## DEPARTMENT OF PUBLIC WORKS

### MEMORANDUM

TO: Kaycee Hathaway  
FROM: Christina Wollman, Planner III *cw*  
DATE: December 30, 2014  
SUBJECT: Old McDonalds Farm CU-14-00005

Emerson Rd.

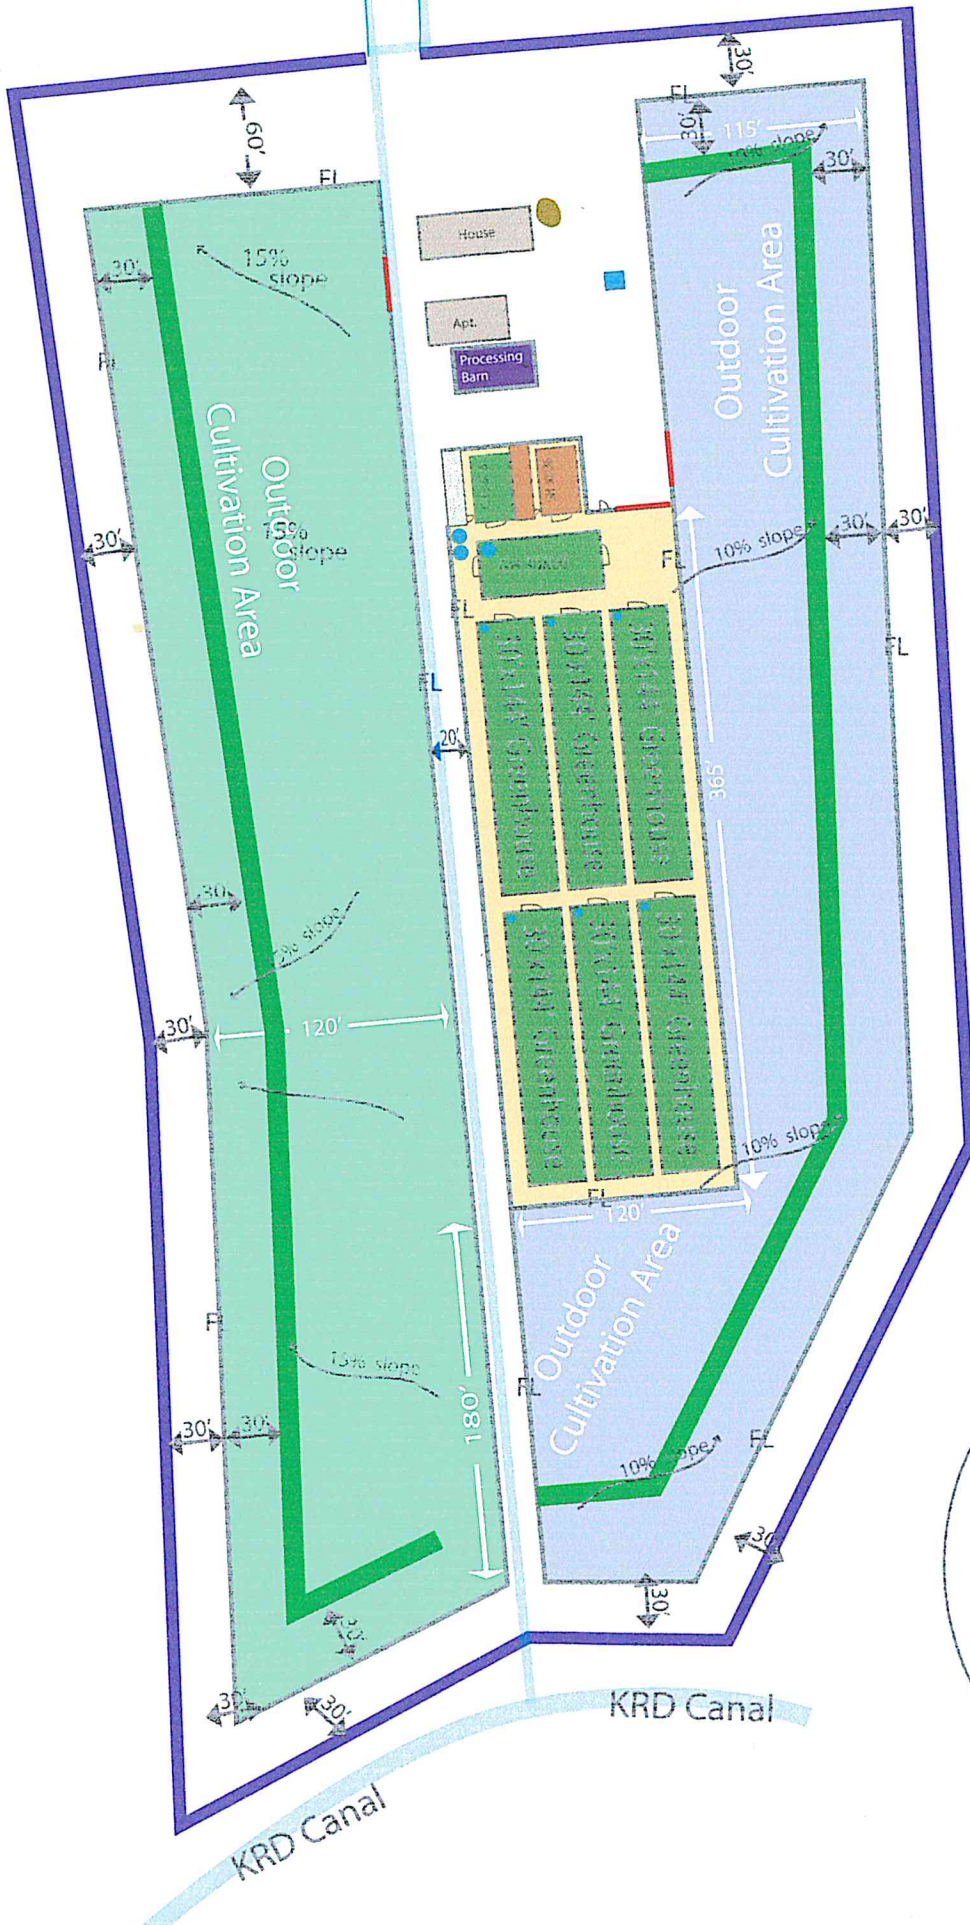
- A. Transportation Concurrency: A Determination of Concurrency Finding has been issued for this project under number TC-14-00014. No mitigation is required of this project.
- B. Site Access: The driveway must be constructed to commercial standards, as shown in the WSDOT Design Manual Exhibit 1340-2. The access as it currently exists does not appear to meet this requirement. Please contact Kelly Bacon at 509-962-7523 to discuss the requirements.
- C. Access Permit: An approved access permit shall be required from the Department of Public Works prior to alteration of the existing access. No new accesses will be allowed.
